Application by Rosefield Energyfarm Ltd. For an Order Granting Development Consent for Rosefield Solar Farm
NSIP Reference: EN010158

Natural England's Response for Deadline 3
Examining Authority's submission deadline: 27 May 2026

Annex 1: Natural England's comments following Issue Specific Hearings

## **Removal of Solar in B6, B7 & B8**

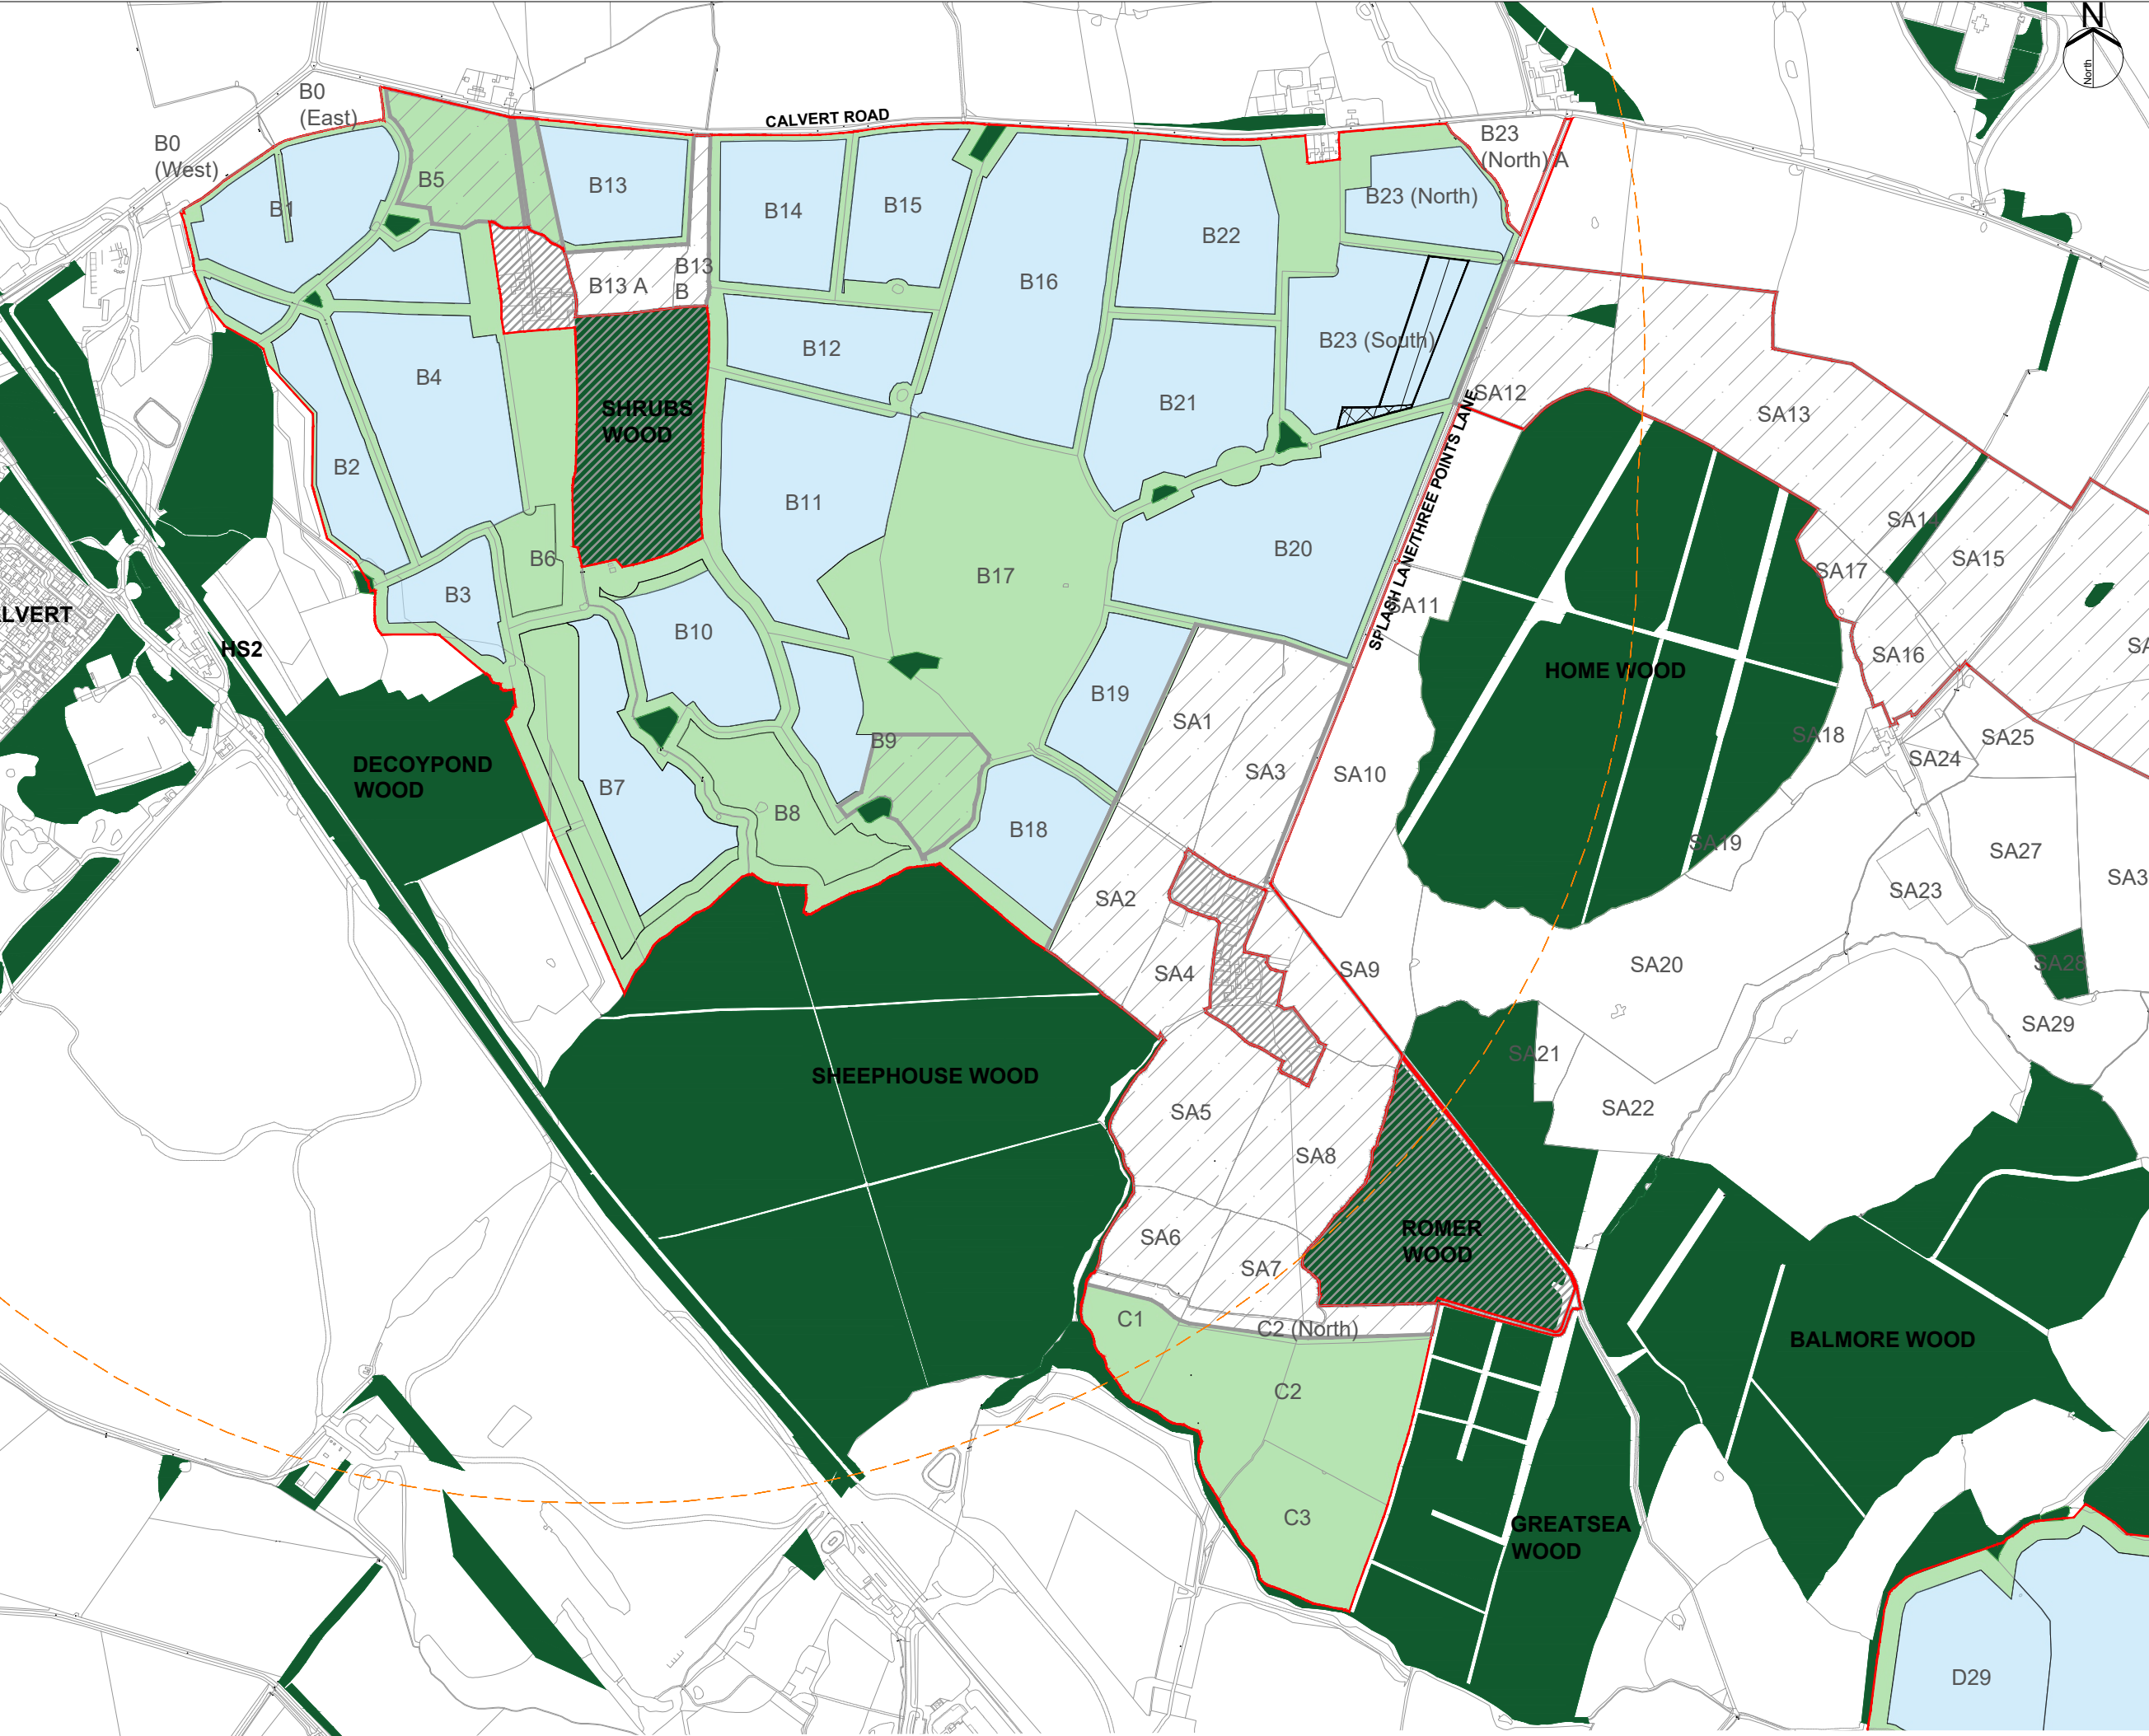
- 1.11 Based on the available data, summarised in NECR 558, as well as an assessment of habitat suitability we know that Fields B6, B7, B8 and likely also B3, are key foraging habitat for Bechstein's bats. This is recognised by the Applicant in their Responses to Relevant and Written Representations;
"It is true that habitat immediately north, east and west of both Decoypond Wood and Sheepphouse Wood SSSI has been identified as one of 'the most frequently used non woodland core foraging areas'" [PDA-006 para ref: RR-026 response on page 25] and *"The Applicant is aware that fields located between Sheepphouse Wood SSSI and Shrubs Wood form an important areas of the Bechstein's bat core sustenance zone."* [REP2-086 para ref: 2.1.39].

- 1.13 Alternative mitigation proposed in fields B9 and B17 is not adequate to offset the impact of losing the existing pastureland B fields, as these do not have the same underlying characteristics and geographical benefits. B17 is a hillside and has a much more exposed aspect than the western B fields, which are low lying and sheltered. Fields B6, 7 and 8 are also especially sensitive in that they link three areas of ancient woodland; Decoypond Wood, Shrubs Wood and Sheepphouse Wood. Two of which have known Bechstein's roosts, and all of which are used for foraging and may support other roosts that have not been identified. Given that surveys can never be completely exhaustive and only ever represent a snapshot in time and a subset of the population, there is a high likelihood that Sheepphouse Wood supports maternity roosts. Access to high quality foraging resource and habitat in close proximity to roosts is important for sustaining the population and the loss of fields B6, 7, 8 may reduce the suitability of the three woods to support future roosts.

- 1.19 We recommend that the avoidance approach is adopted consistently, with all grazed fields protected from development throughout the order limits. Enhancements should focus on the retention of grazing as well as increasing the proposed buffers. This would not only protect current use and value, but also to ensure future resilience is not compromised on a scale and geographic spread that recognises the value of this existing habitat and the National importance of the Bernwood Bechstein's population that it supports.
